A46 Newark Bypass

Scheme Number: TR010065

**Statement of Common Ground
with Nottinghamshire County Council**

March 2025

FARNDON UNDERPASS

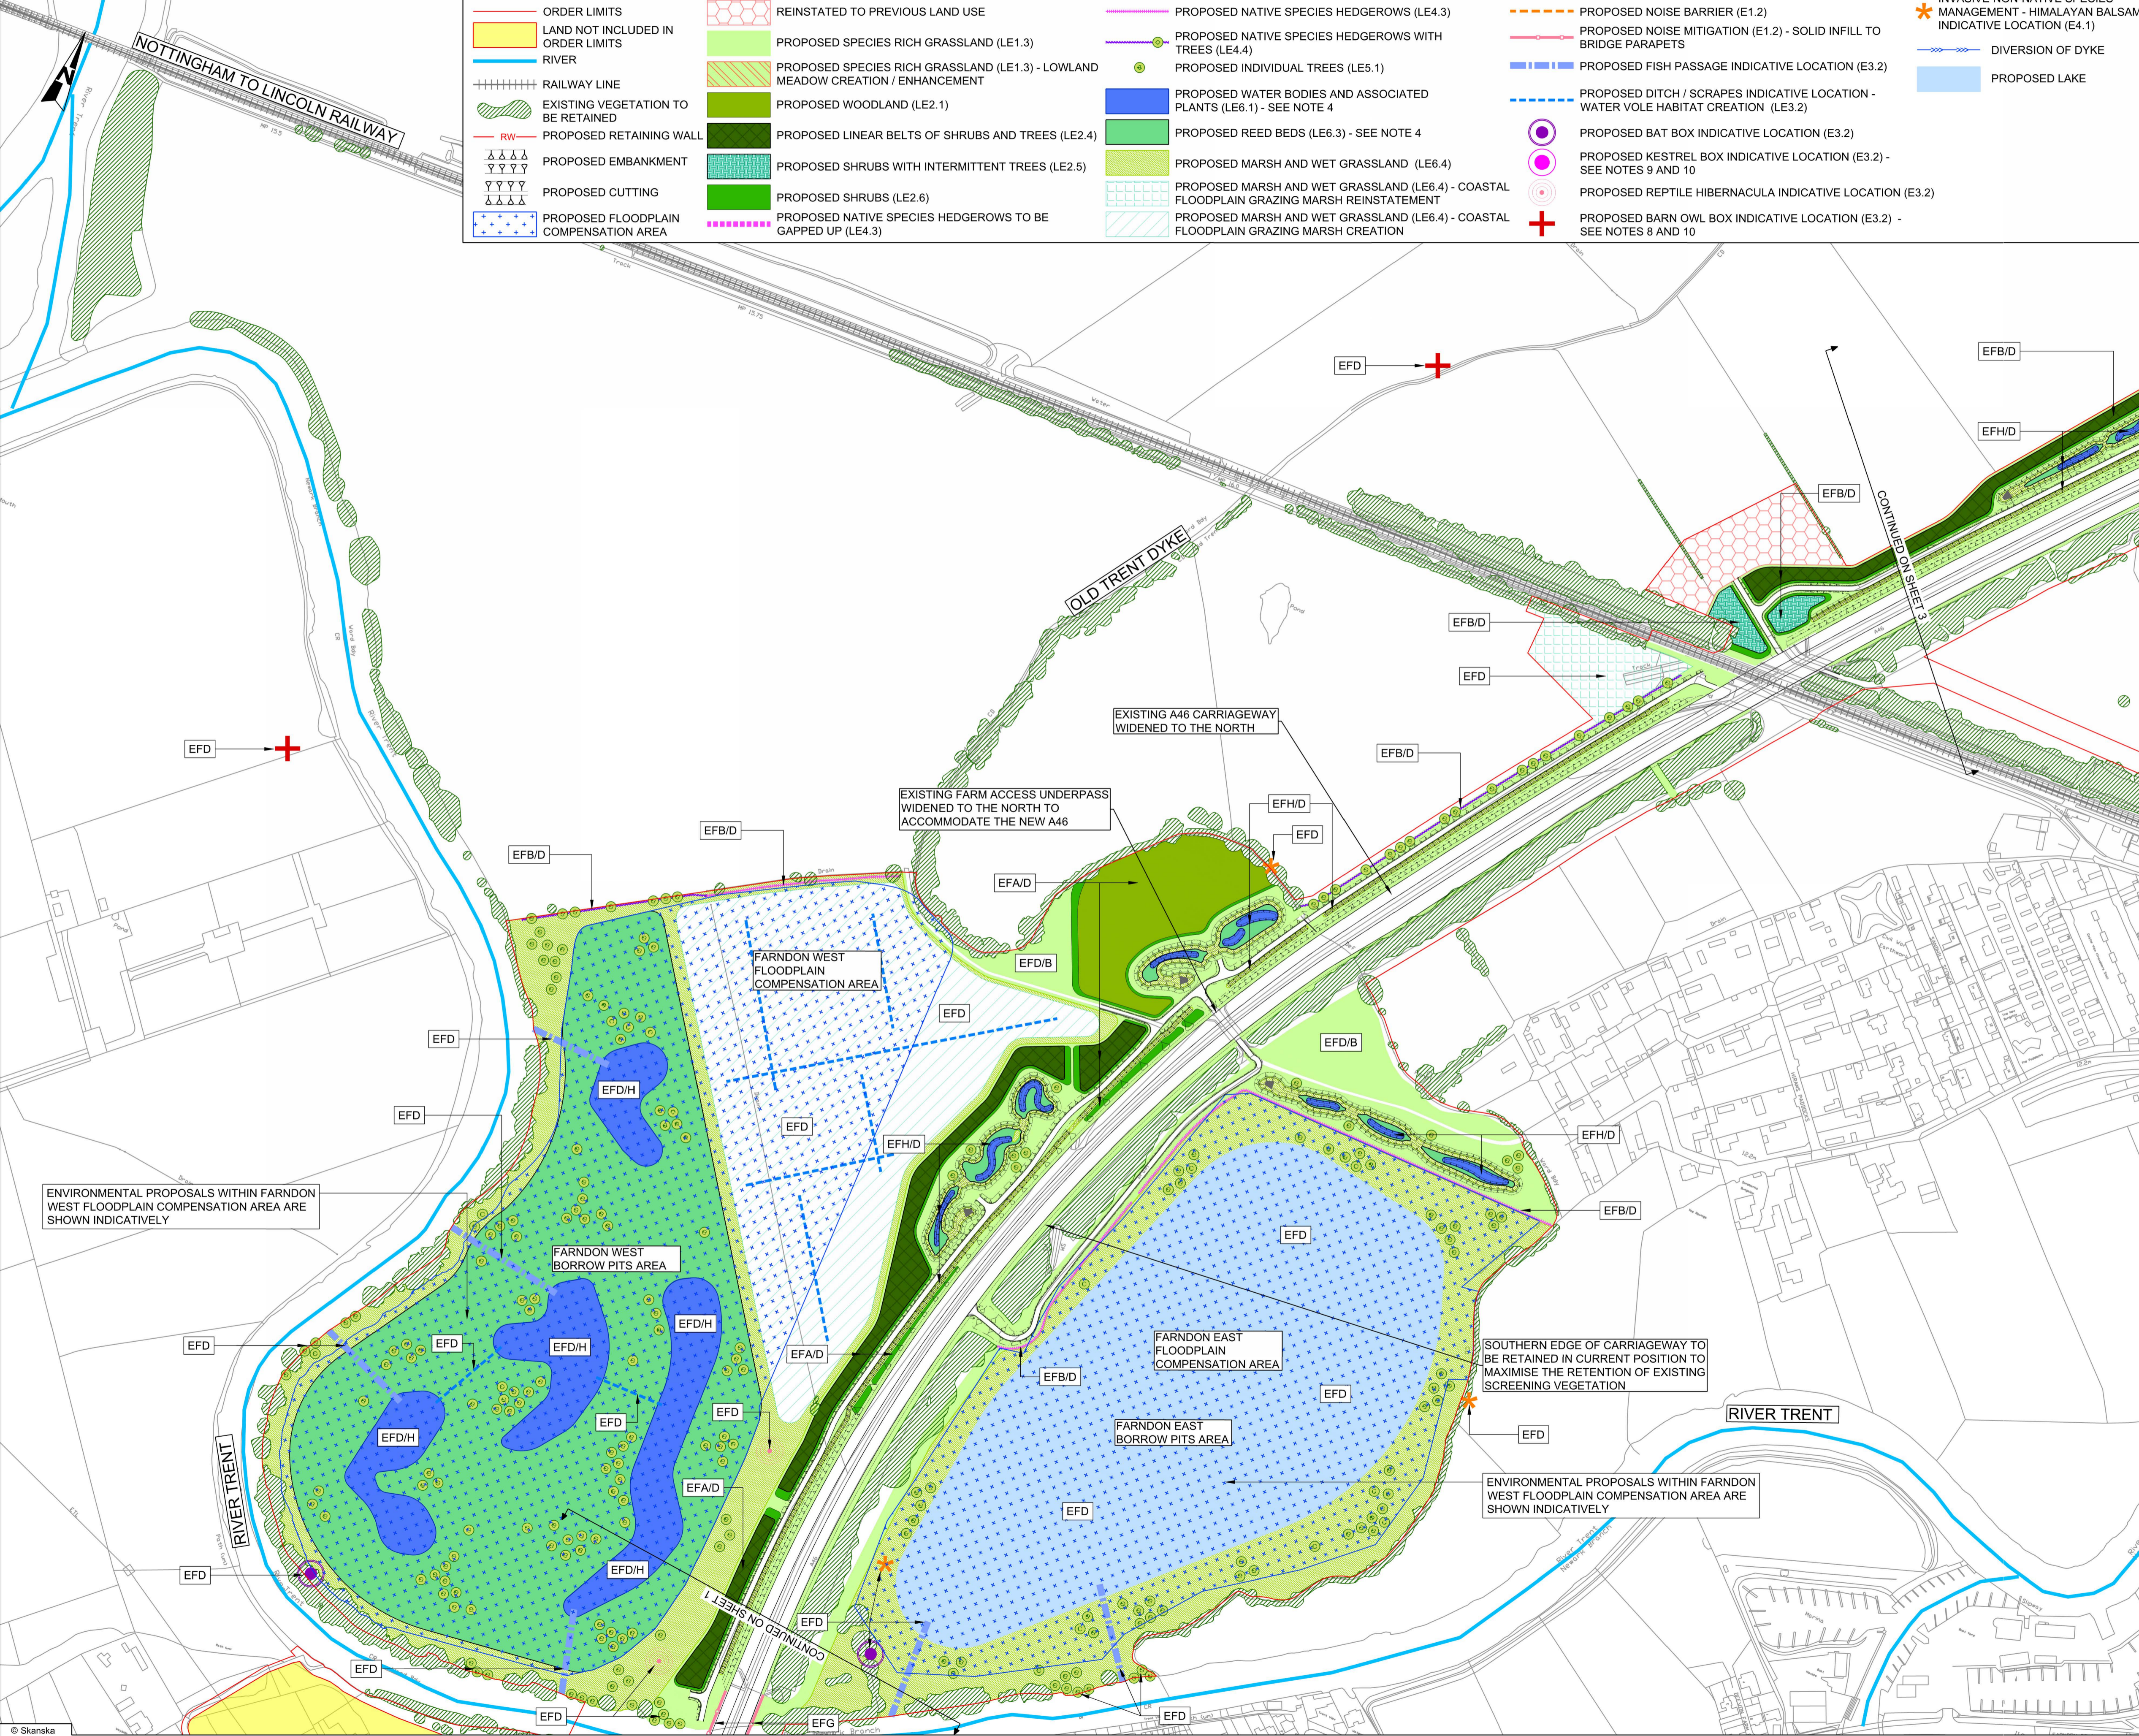
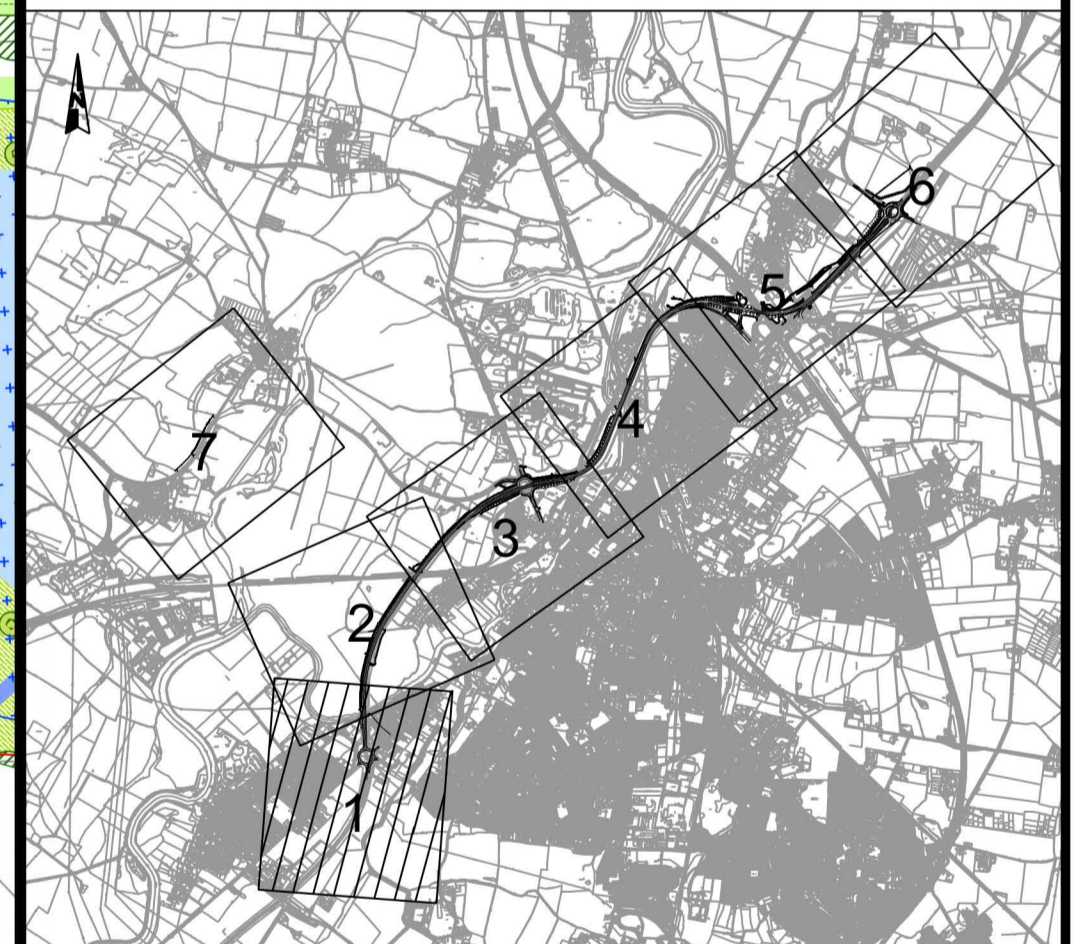
5.	PRoW		Farndon A46 roundabout The plans indicate that the Farndon Underpass will remain open throughout the works which is good. As you are aware the land adjacent to Crees Lane is currently used by members of the public as a walking route, we are also aware that National Highways are planning to use this as a compound. We would support the opportunity to create a public footpath at this location to link the underpass with Footpath No.5 and Bridleway No.2. Farndon A46 roundabout - the land which is set out for the works compound adjacent to Crees Lane has a number of unrecorded desire lines through it. It would be advantageous to see these formally recorded and set out following completion of the Scheme.	Following feedback received as part of the statutory consultation, the temporary diversion of bridleway BW2 was changed, and an alternative route was presented as part of the targeted consultation on the Scheme between 14 March and 16 April 2023. Following further feedback received as part of the targeted consultation the temporary diversion of the bridleway will be only for use by equestrians. Pedestrians and cyclists will utilise the existing footpath FP5 from the River Trent to gain access to the route adjacent to Crees Lane shown within the Order Limits. The unrecorded desire lines are on a piece of land that has been identified for temporary use as part of Scheme, any activity to formally record these desire lines as Public Rights of Way would need to be undertaken by stakeholders, including NCC, outside of the Scheme.	Agreed	04/11/2024
